From: Richard Sherman
Sent: 27 October 2021 15:13
To: Planning Scanning
Subject: FW: FG/152/21/HH - 1 Upper West Drive, Ferring
Attachments: Proposed Plans - Extension.pdf

From: Richard Sherman [REDACTED]
Sent: Monday, October 25, 2021 3:56 PM
To: Carl Moore [REDACTED]
Subject: FG/152/21/HH - 1 Upper West Drive, Ferring

PROPOSED FIRST FLOOR PLAN 1:50

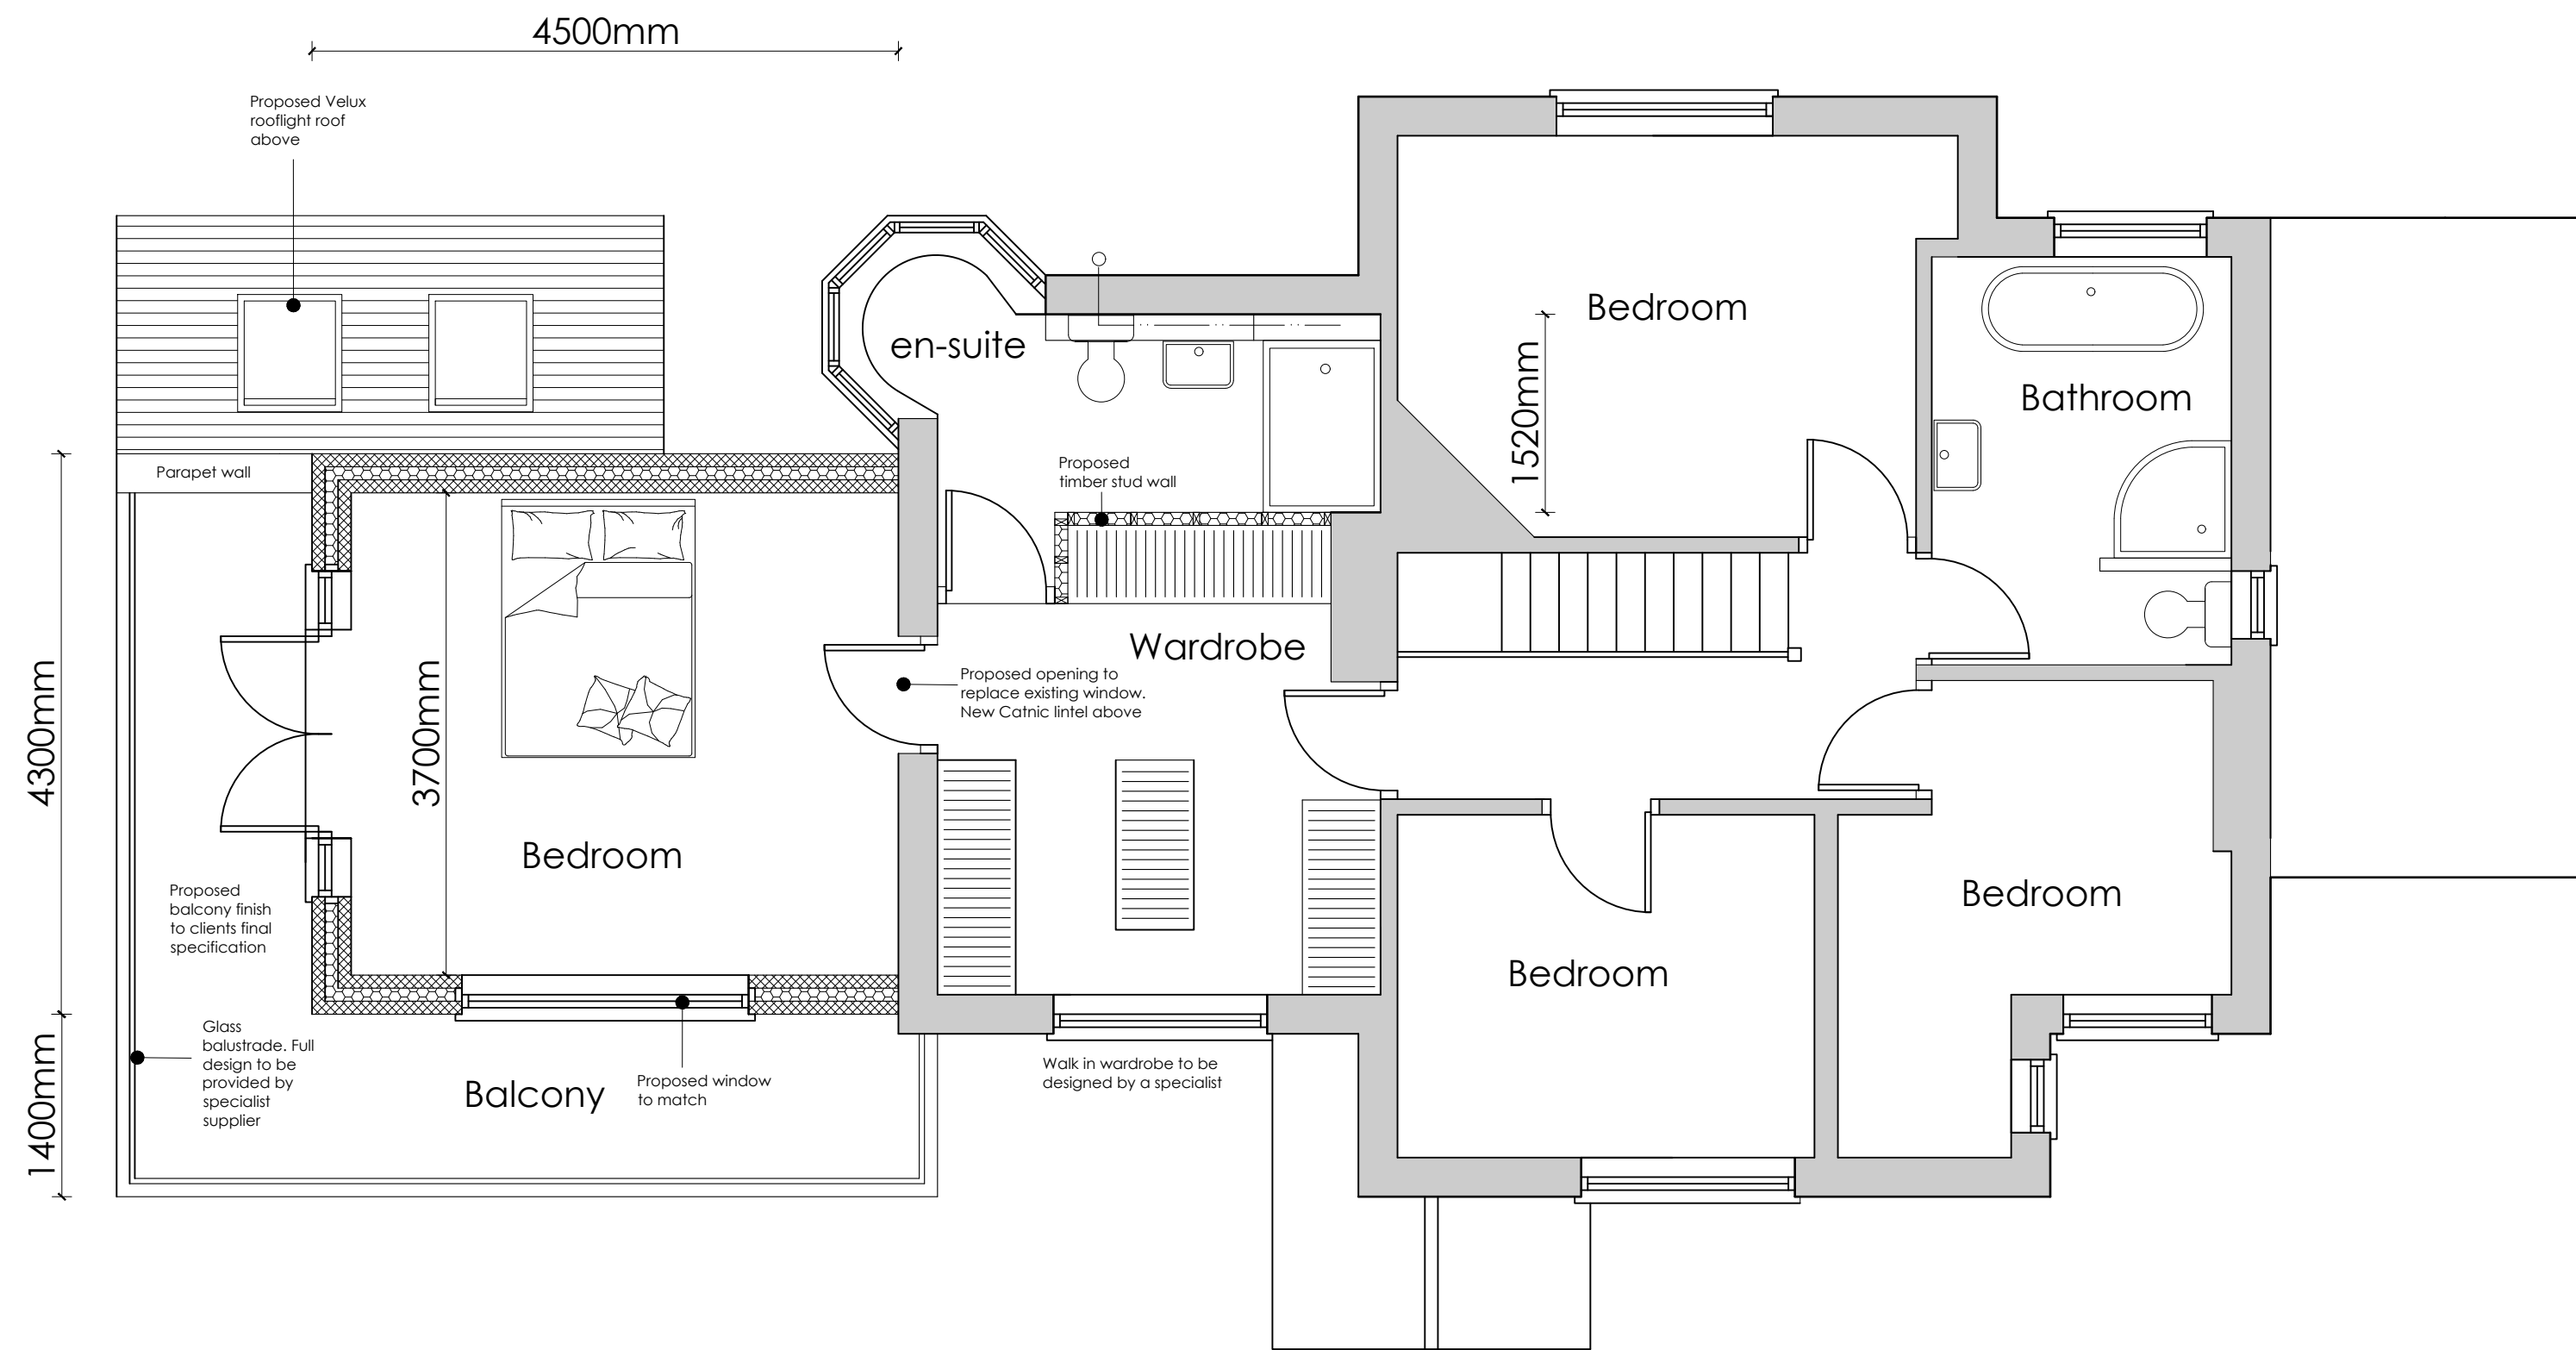
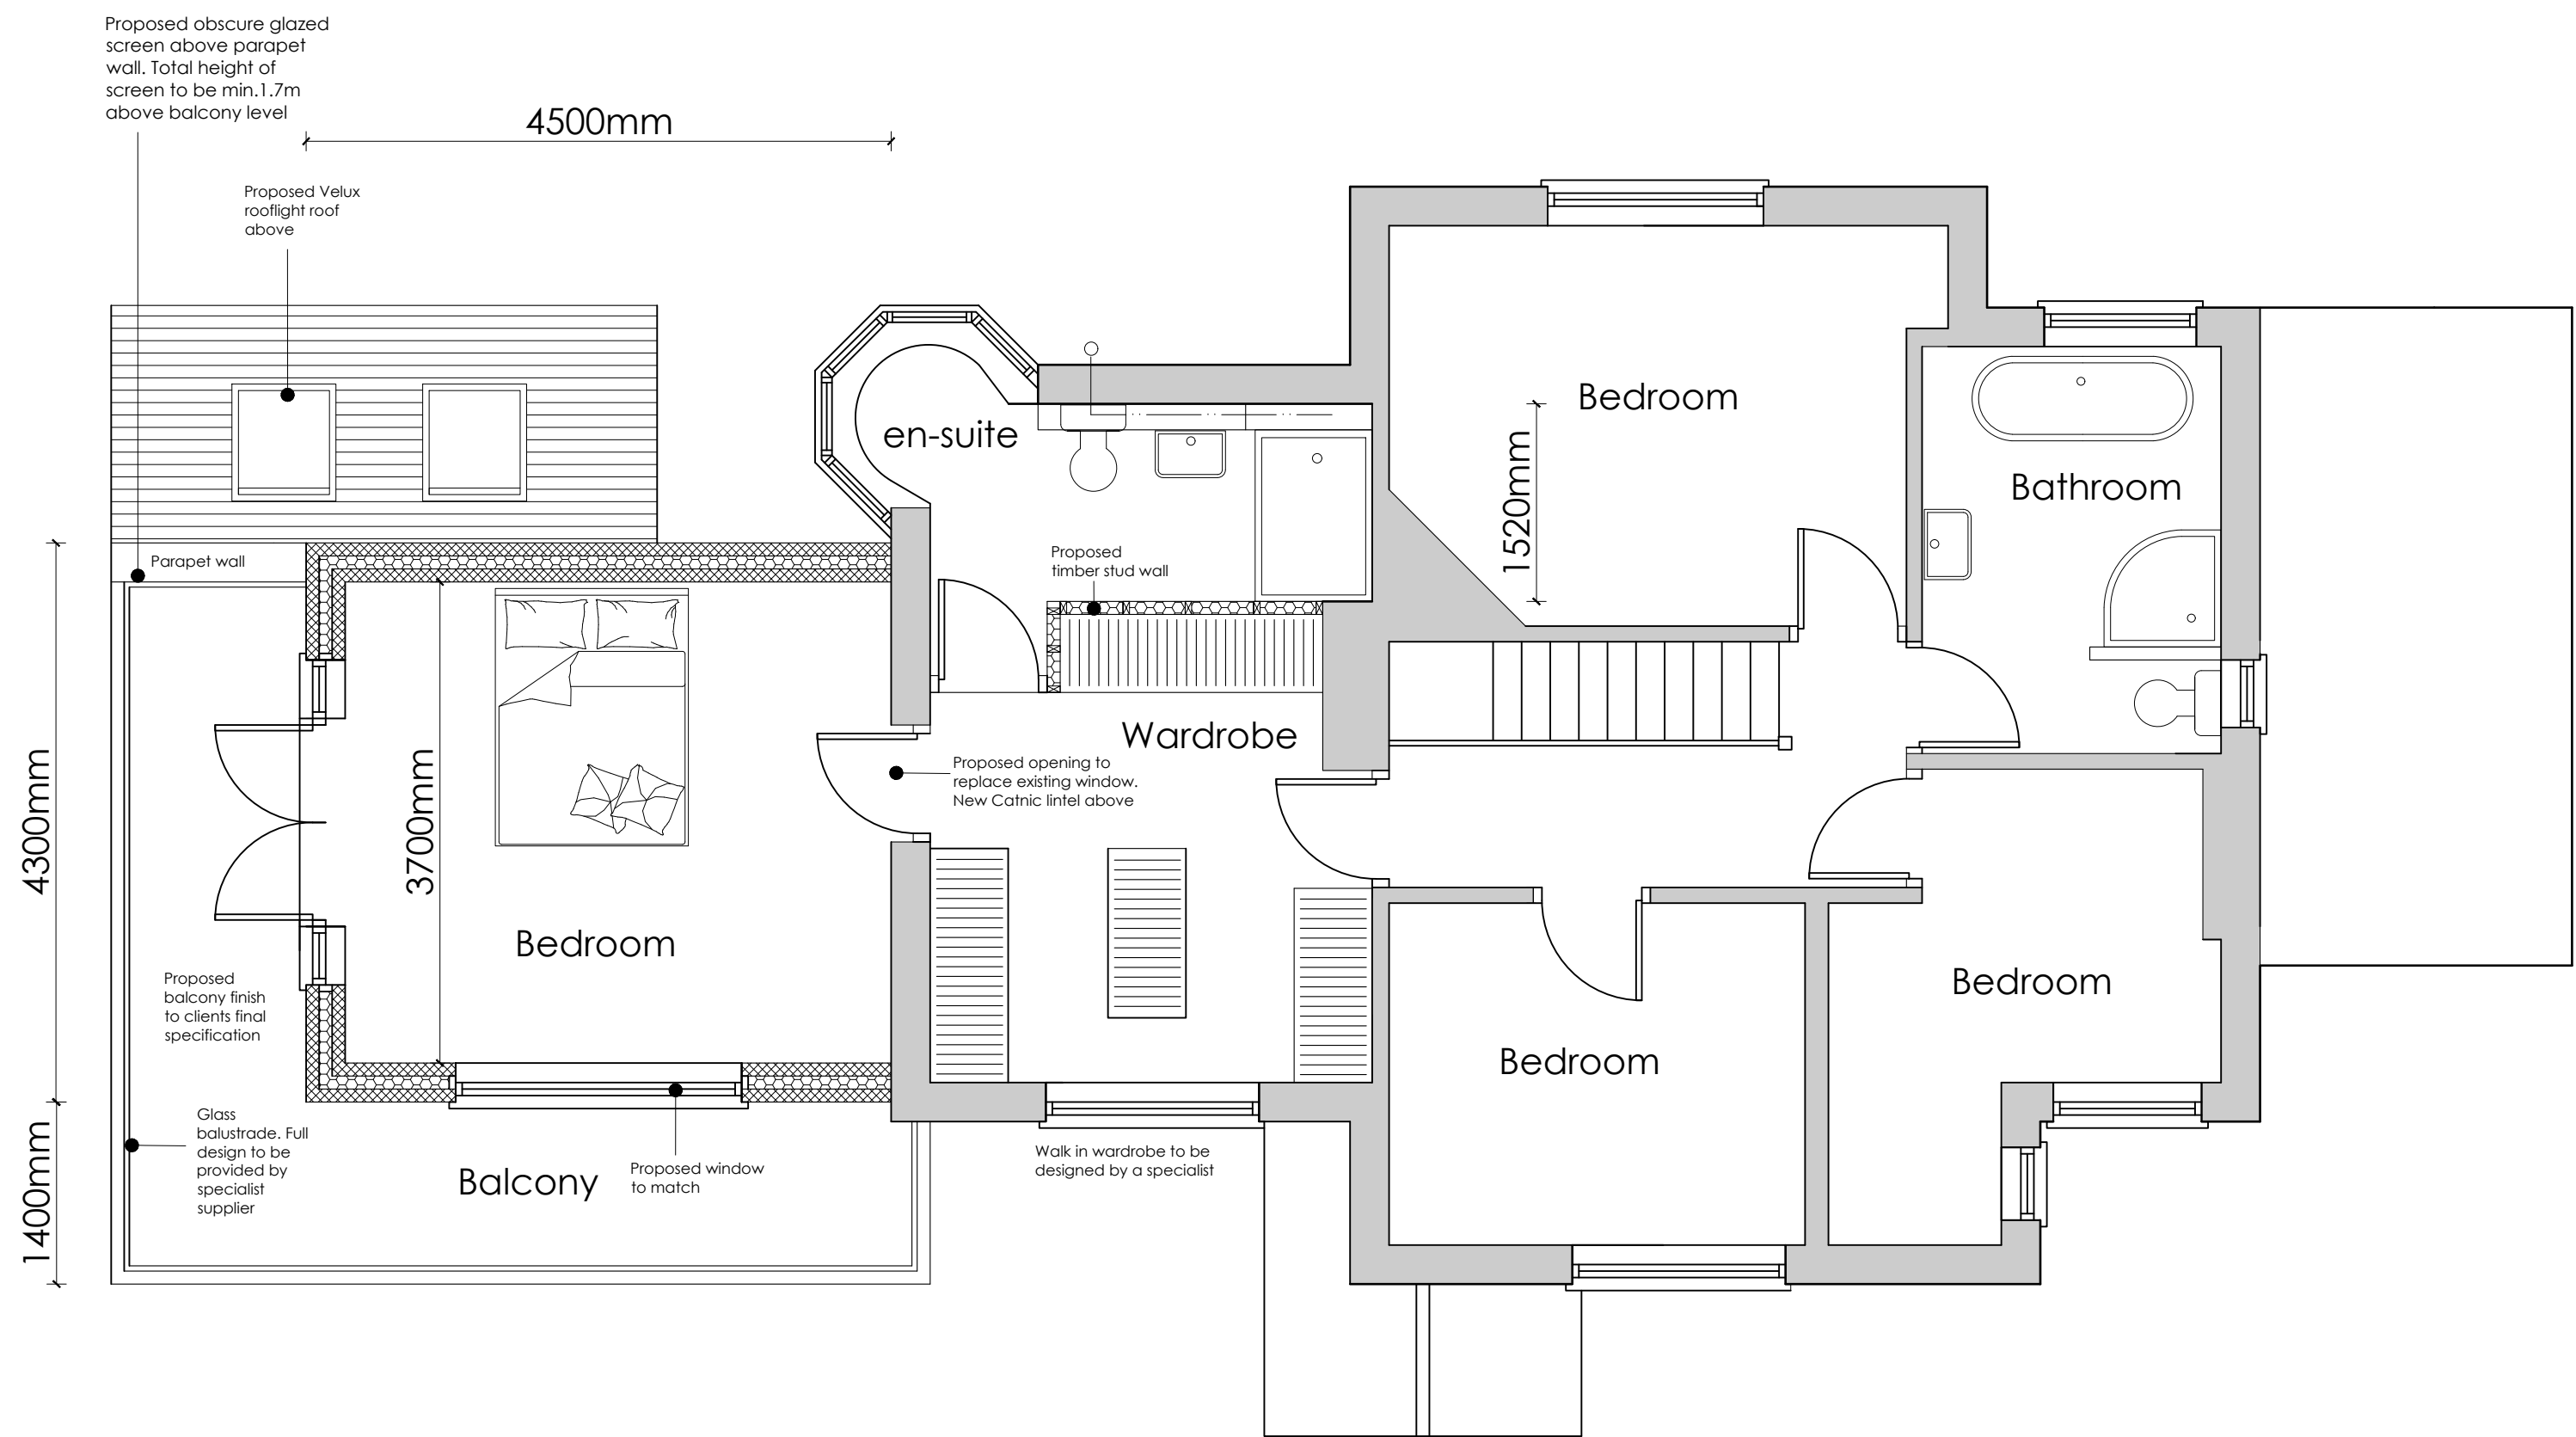
1. We need you to please submit a new 'Proposed Elevations' plan as the current 'Proposed Elevations' has the proposed west elevation labelled as Existing West Elevation so this needs to be clarified that it is the proposed west elevation?
2. Also on the new plan please can you show the height measurements of the proposed new parapet wall to the west elevation balcony please? As we need to know how tall this is in order to work out how much obscured glazing is needed in order to reduce overlooking effects to neighbouring property to west. Therefore otherwise please can you submit a new plan with a obscured glazing screen to a height of 1.7m to the west balcony elevation in order for it to comply? If you don't know the exact specifications or your client doesn't know then we can condition this aspect.

Please find attached the revised plan as requested. I have included the 1.7m obscure screen on the elevations and first floor plan. I should also be grateful if you could include this within the planning conditions.
